OCTOBER 6, 2022

**BUILDING DEPARTMENT COMMENTS:**

**PERMIT SET DRAWINGS**

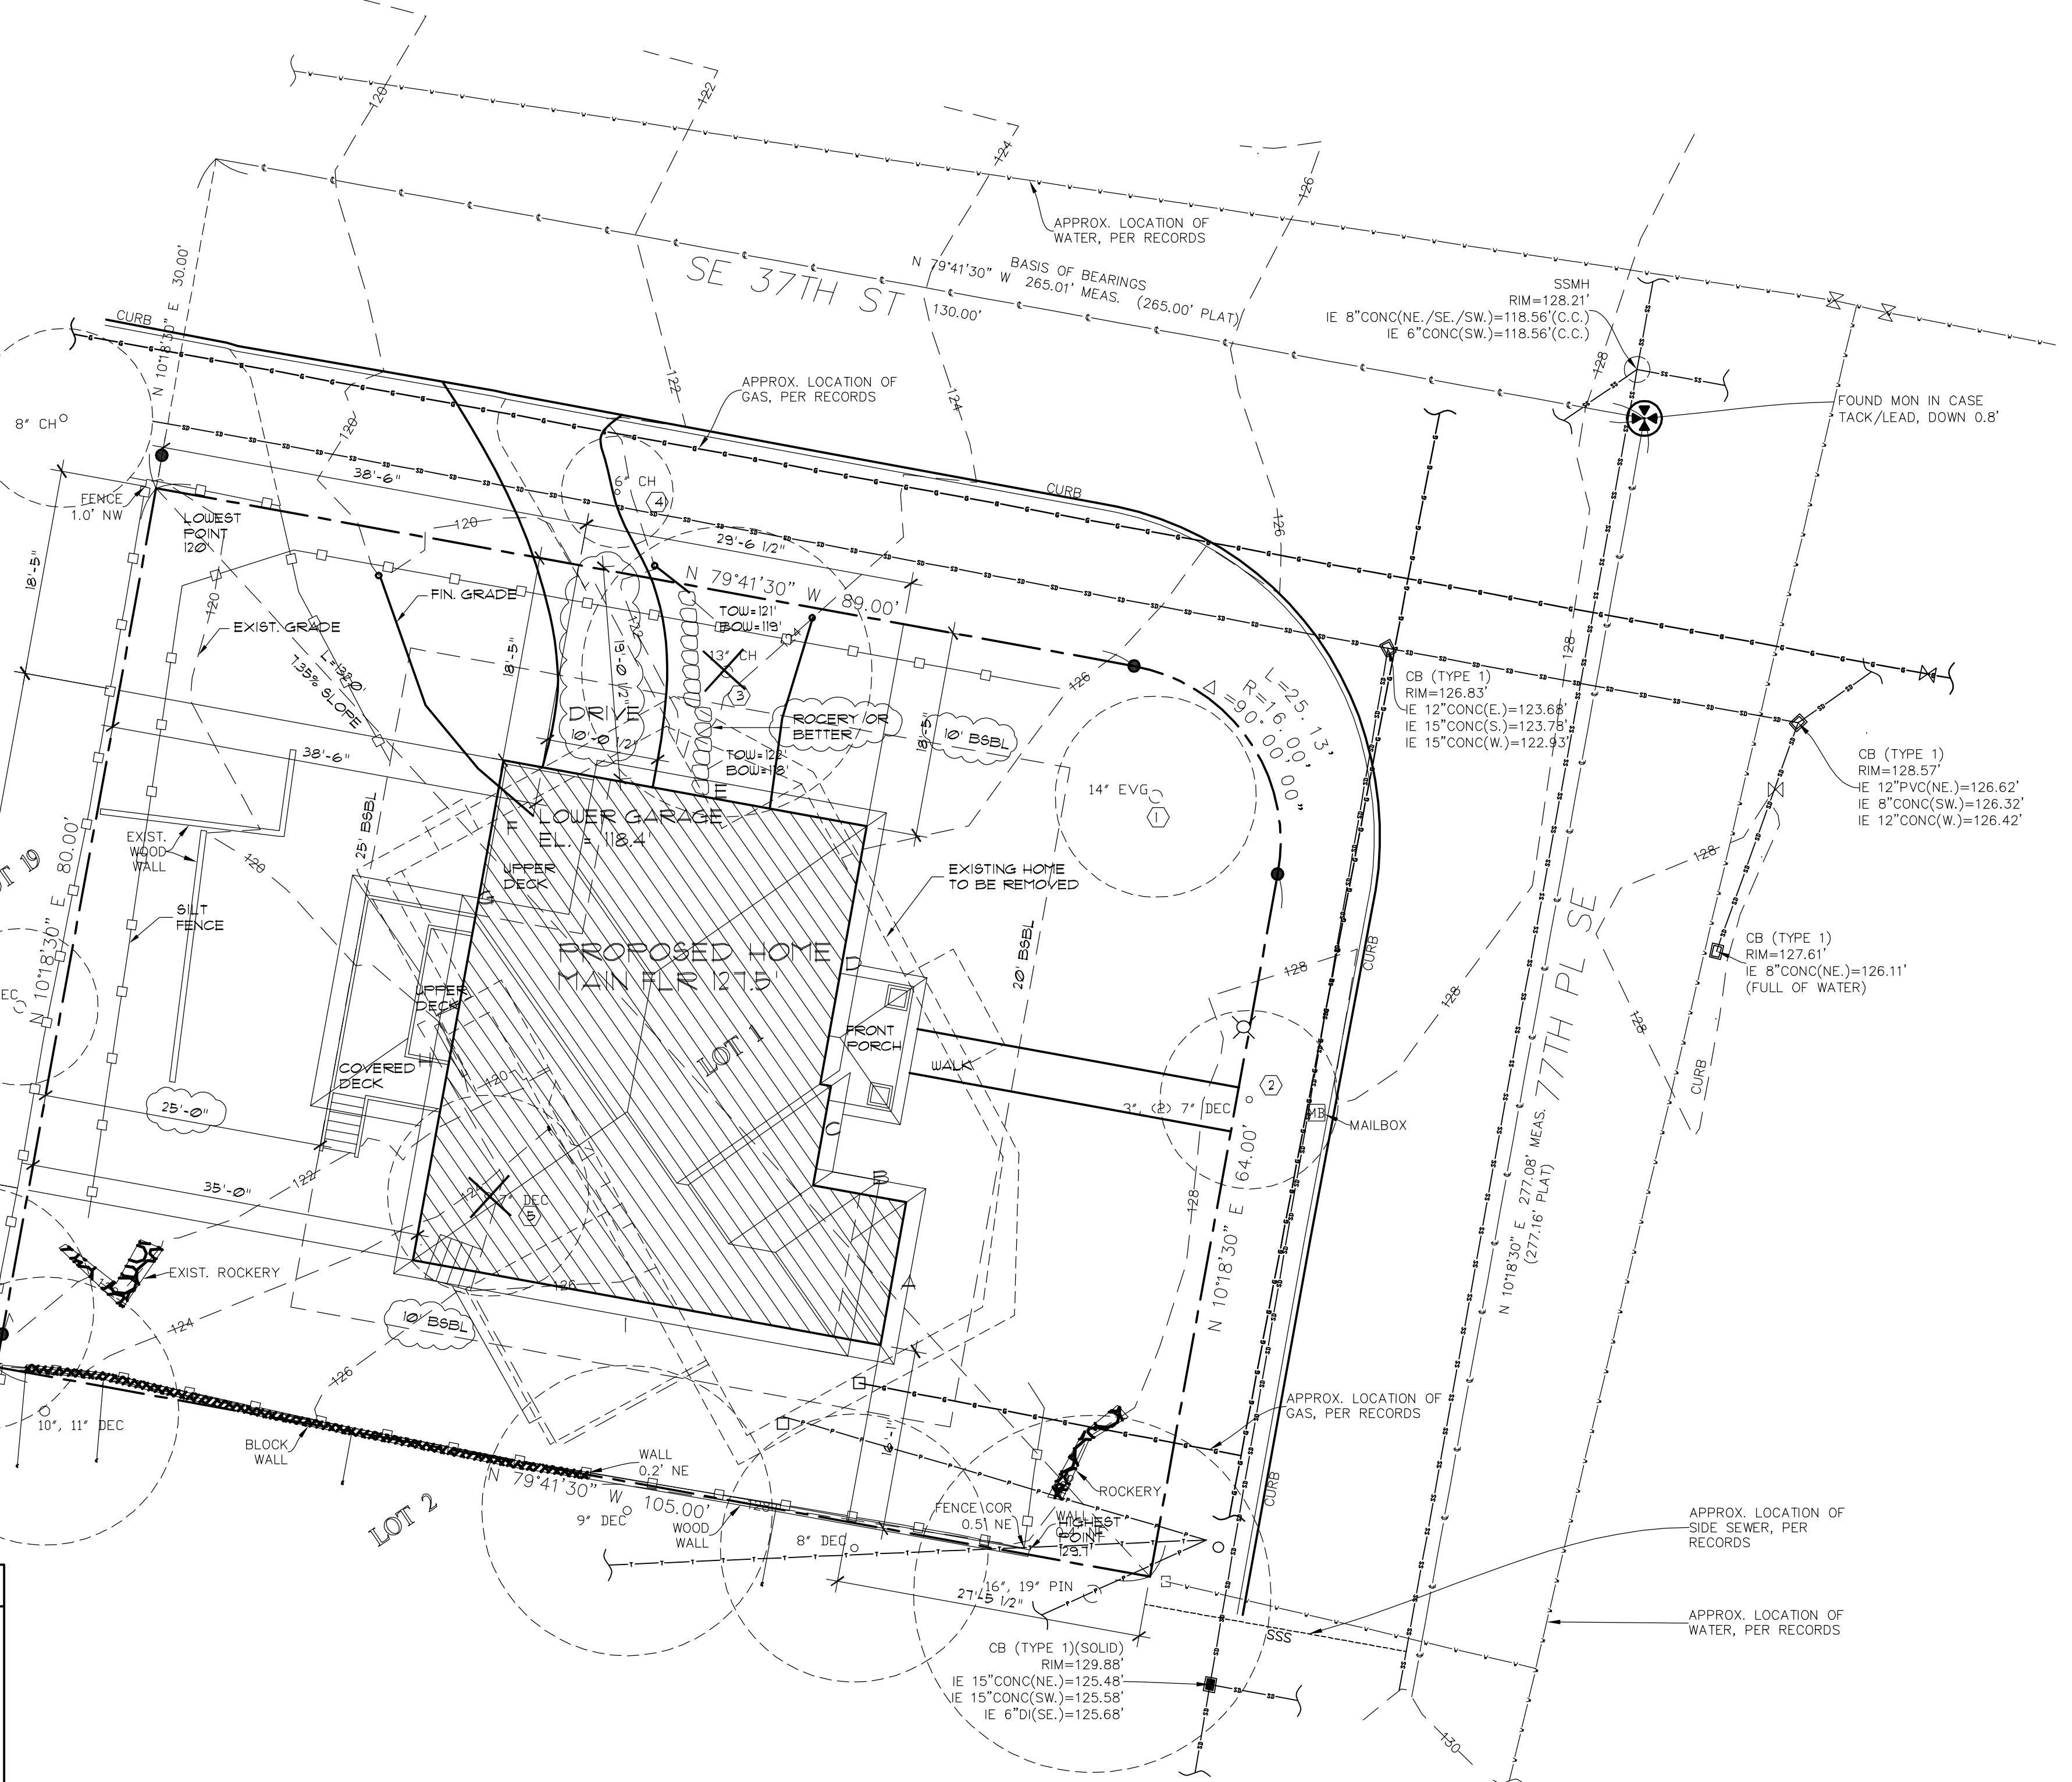
**SITE PLAN:**

REVISED SETBACKS TO 10'

RIGHT ELEVATION

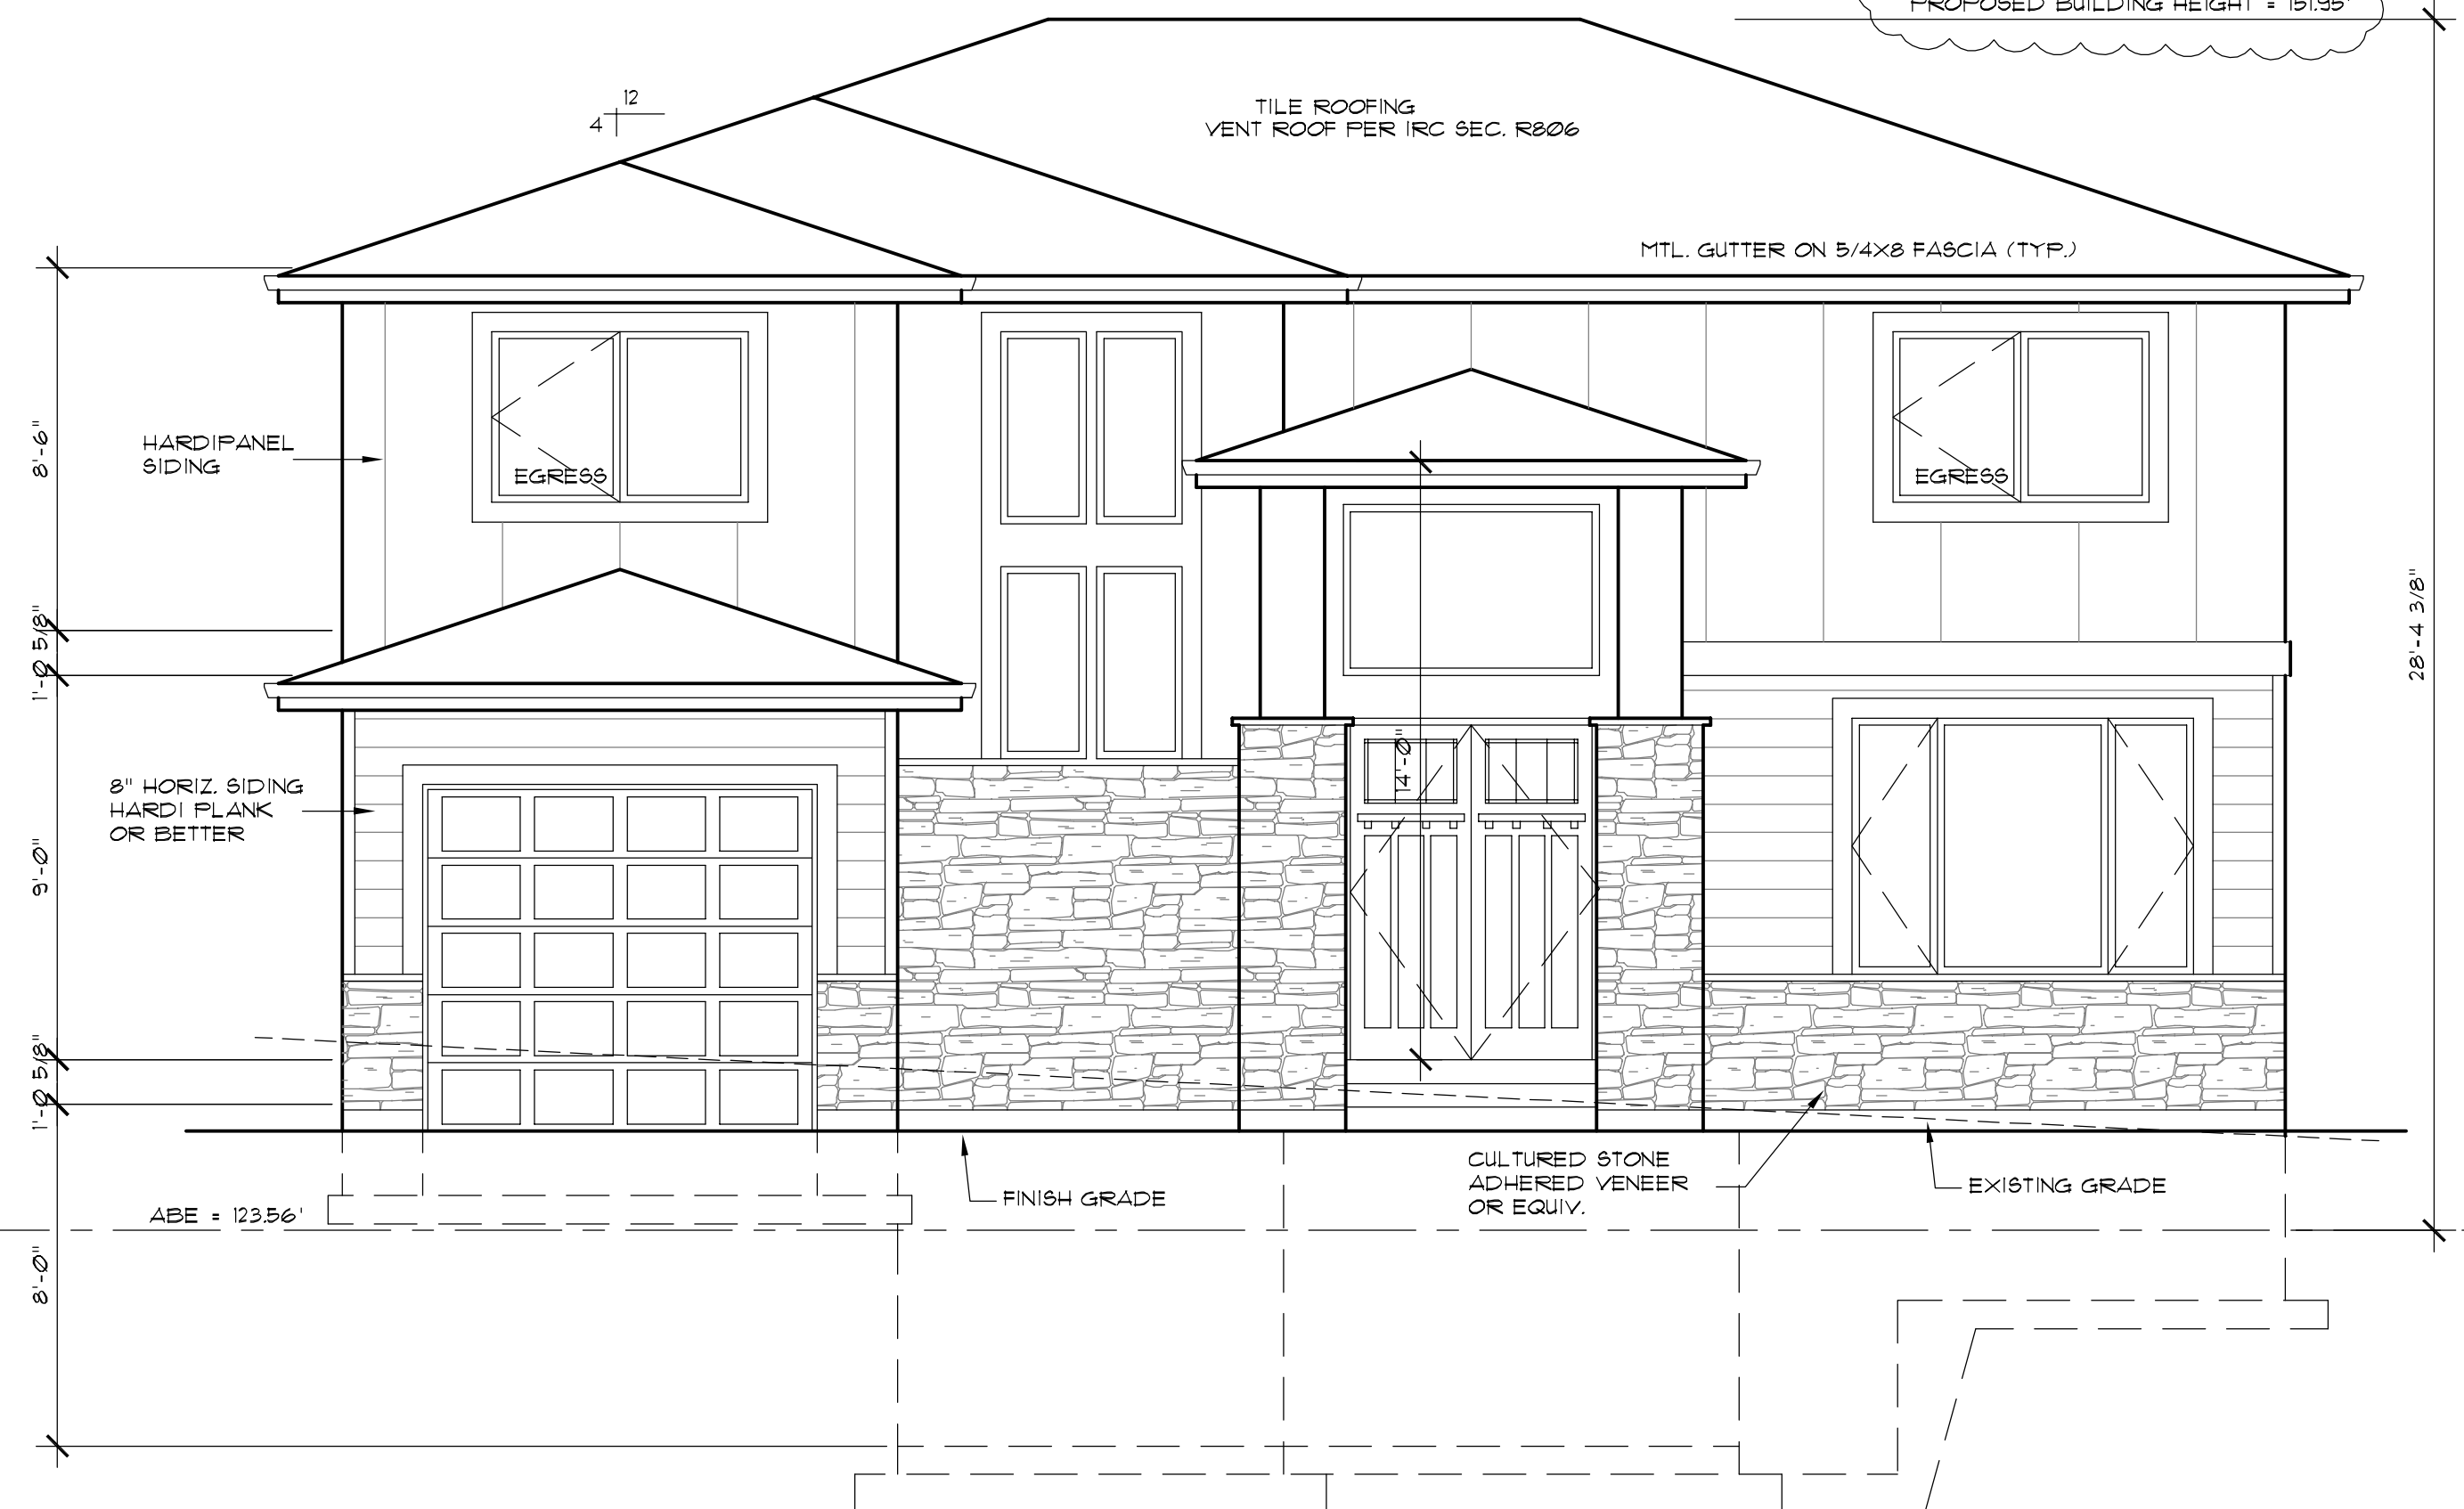
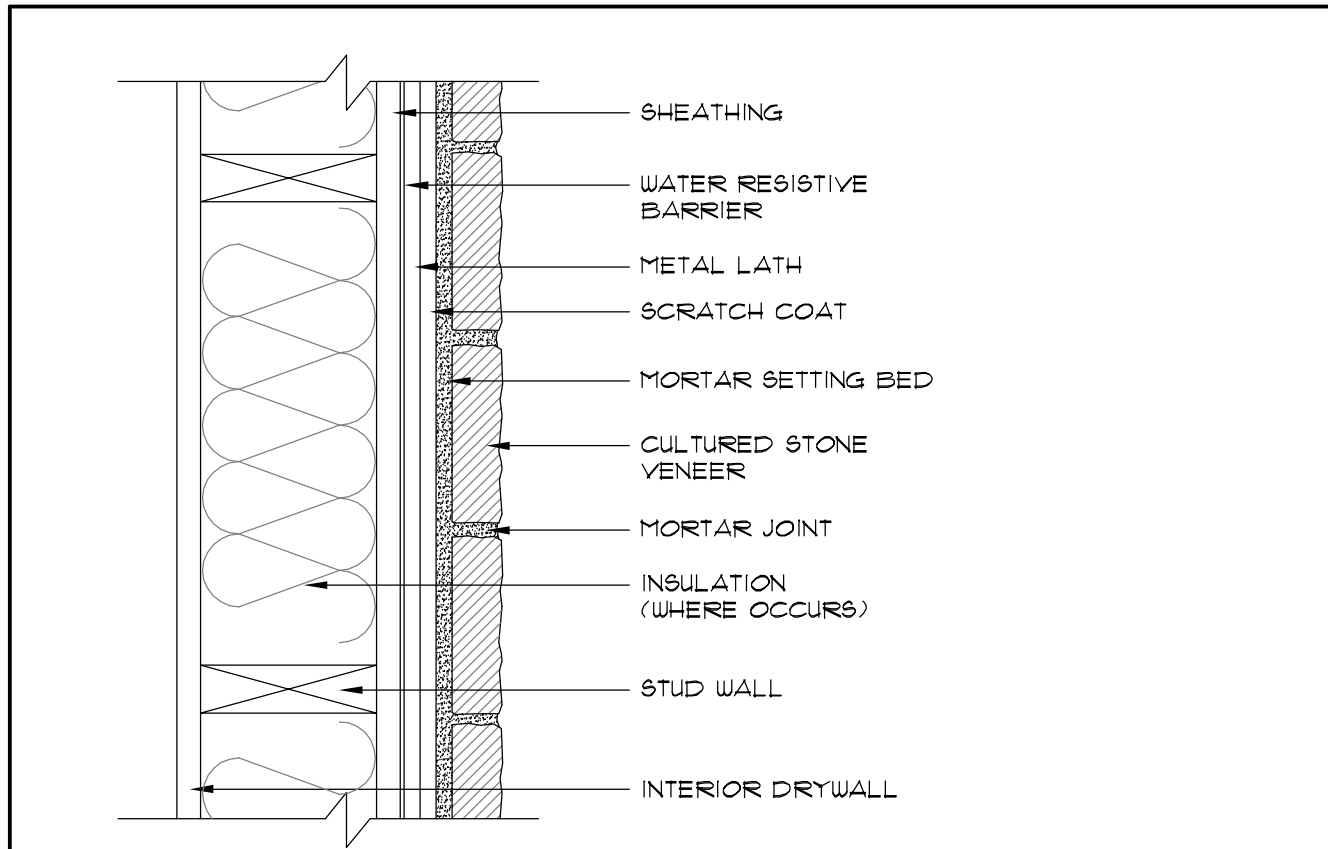
**ELEVATION DRAWINGS:**

PROPOSED HEIGHT SHOWN ON ALL ELEVATIONS SHEET A5  
EXISTING AND FINISH GRADE SHOWN ON ALL ELEVATIONS SHEET A5
